From: Sarah Burrow <Sarah.Burrow@arun.gov.uk>
Sent: 01 April 2022 12:52
To: Planning.Responses <Planning.Responses@arun.gov.uk>
Cc: Amber Willard <Amber.Willard@arun.gov.uk>
Subject: RE: Planning Consultation on: BN/28/22/DOC

Engineers Comments Regarding Surface Water Drainage

Application No: BN/28/22/DOC
Registered: 10th March 2022
Site Address: Land the rear of Highground House and Orchard End Barnham
Description of Works: Approval of details reserved by condition imposed under BN/114/21/PL relating to conditions 3-schedule of materials and finishes, 4-renewable energy, 6-Construction Management Plan, 8-bin storage, 10-covered and secure cycle parking spaces, 11-electric vehicle charging points, 12-surface water drainage, 14-foul water drainage and 17-external lighting.

DRAWING TITLE
DRAINAGE LAYOUT

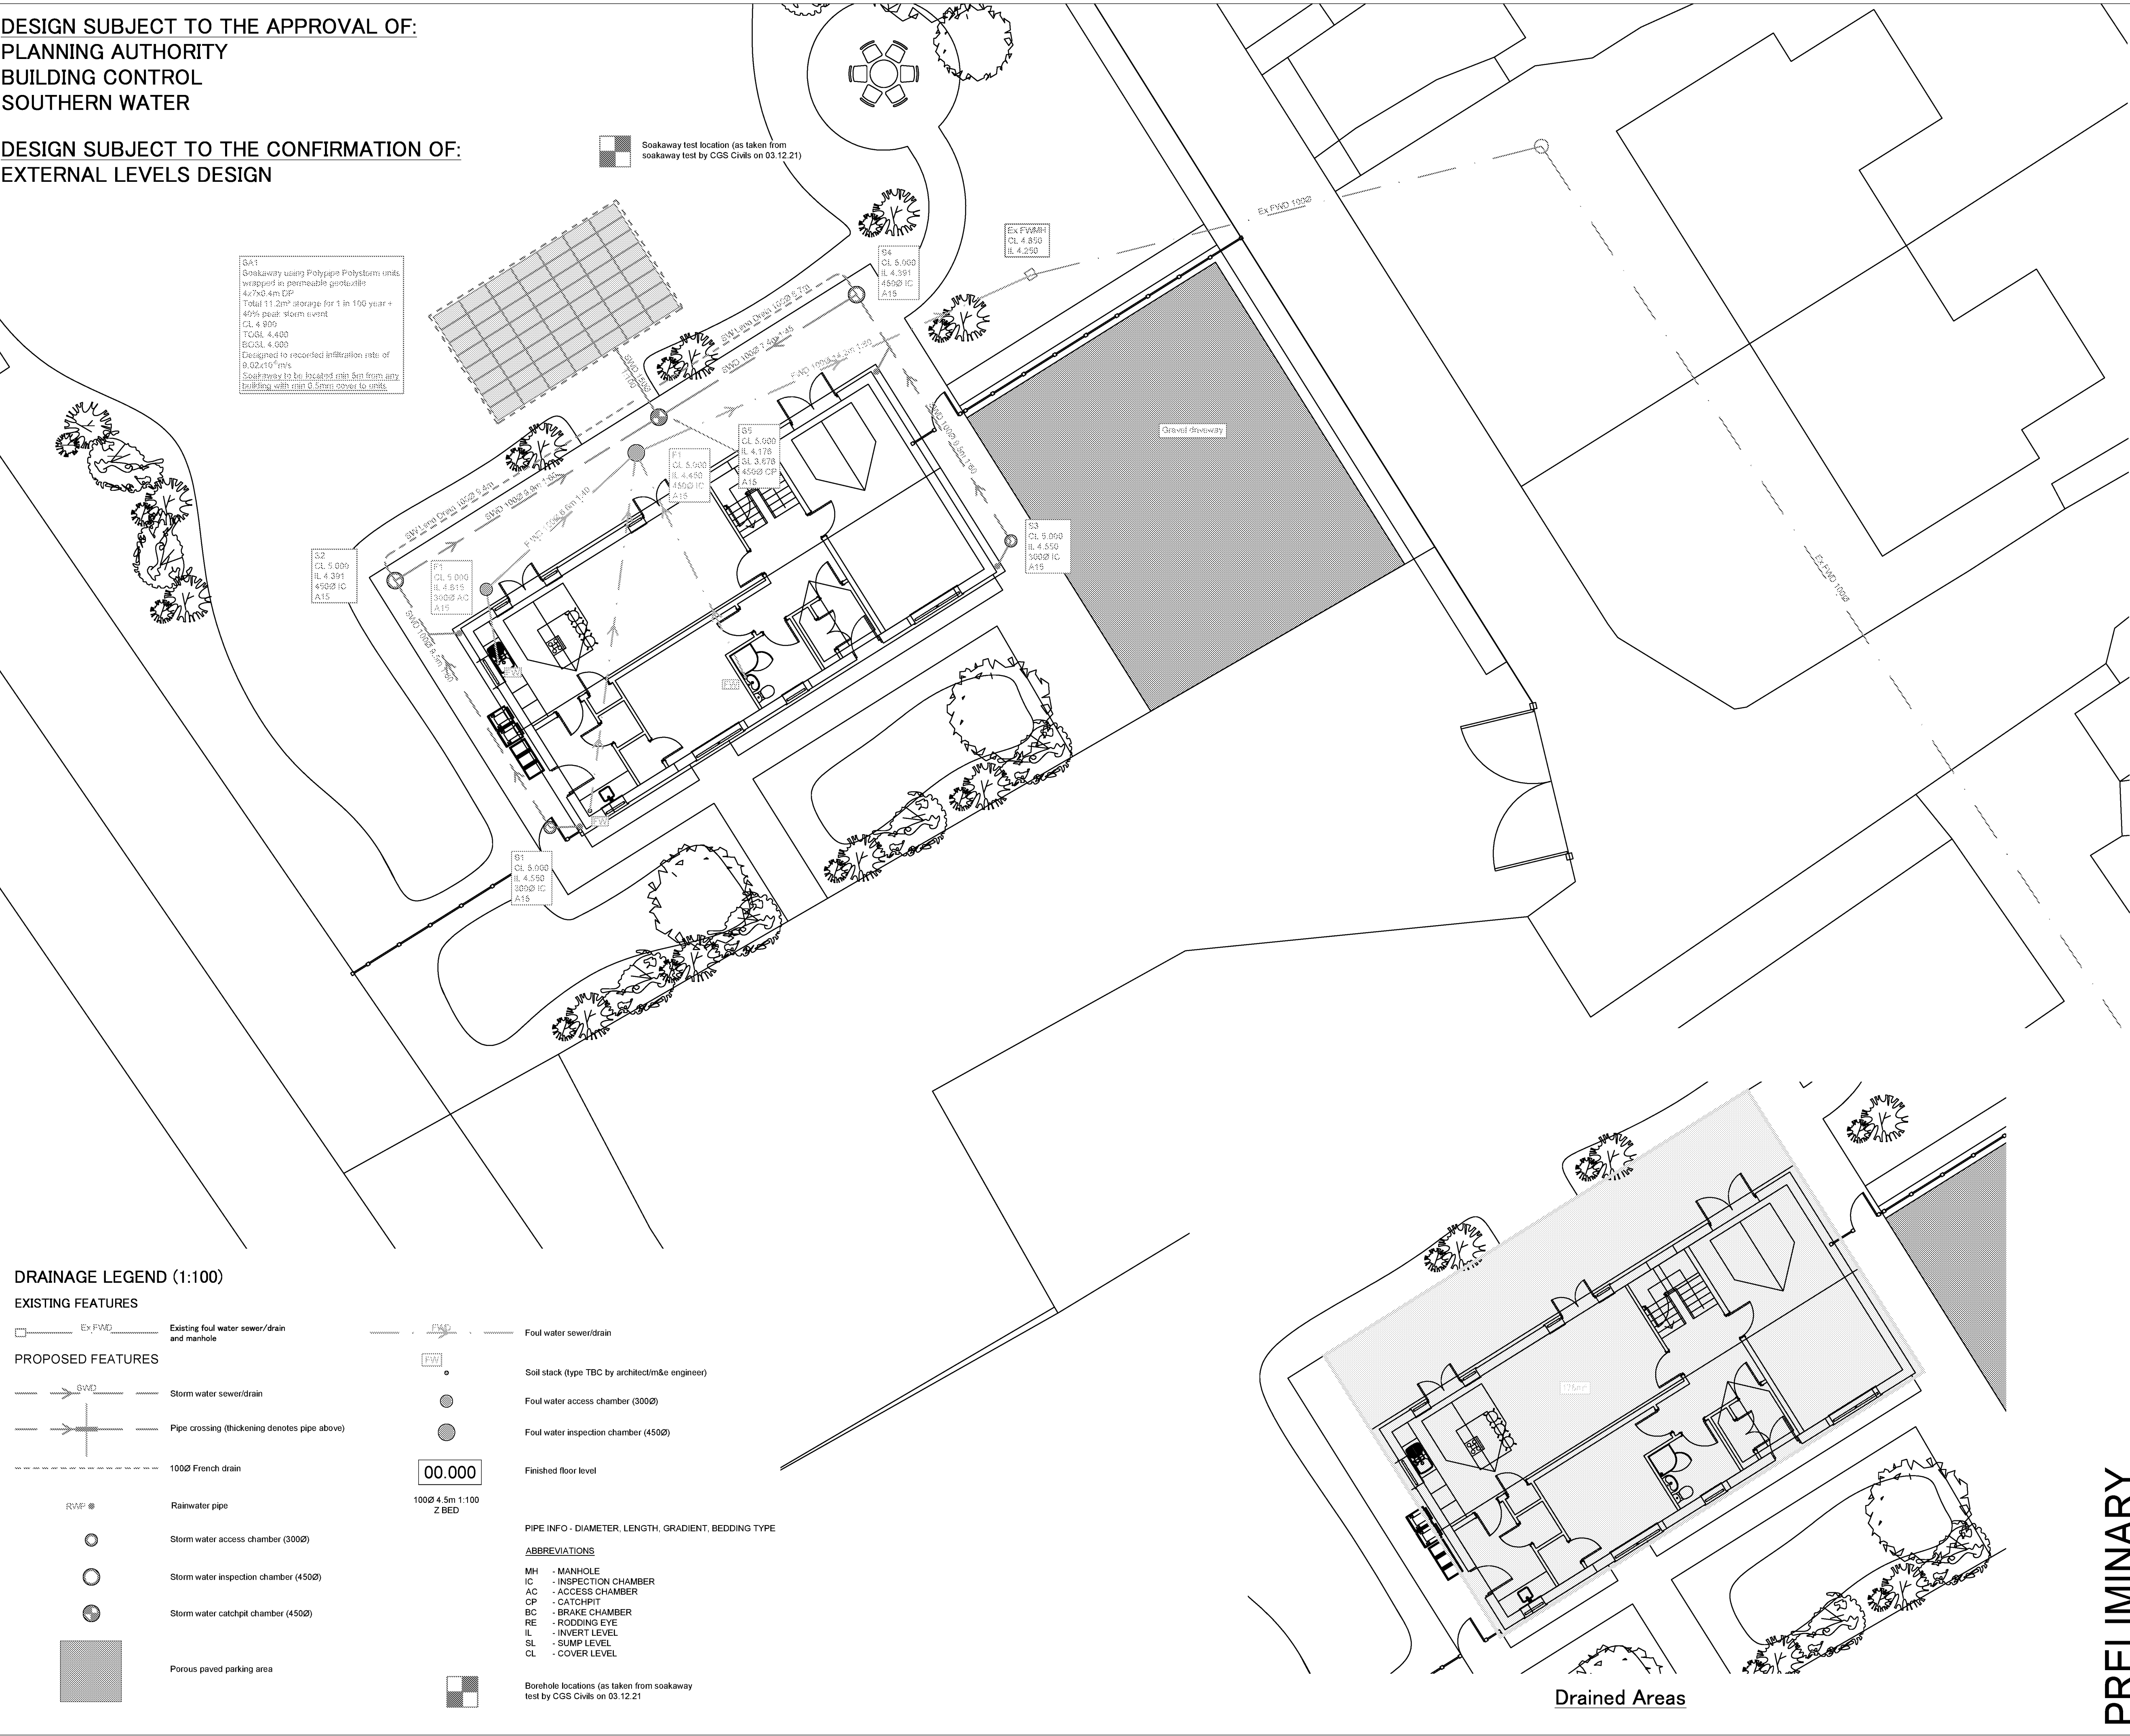
One minor alteration is requested before I recommend discharge of said condition; please can the invert level of the incoming pipe to the soakaway be shown on the drainage layout. At present it could easily be misunderstood to be laid at the base of the soakaway and it needs to be at least 74mm from the base (above the 1 in 10 +40% level).
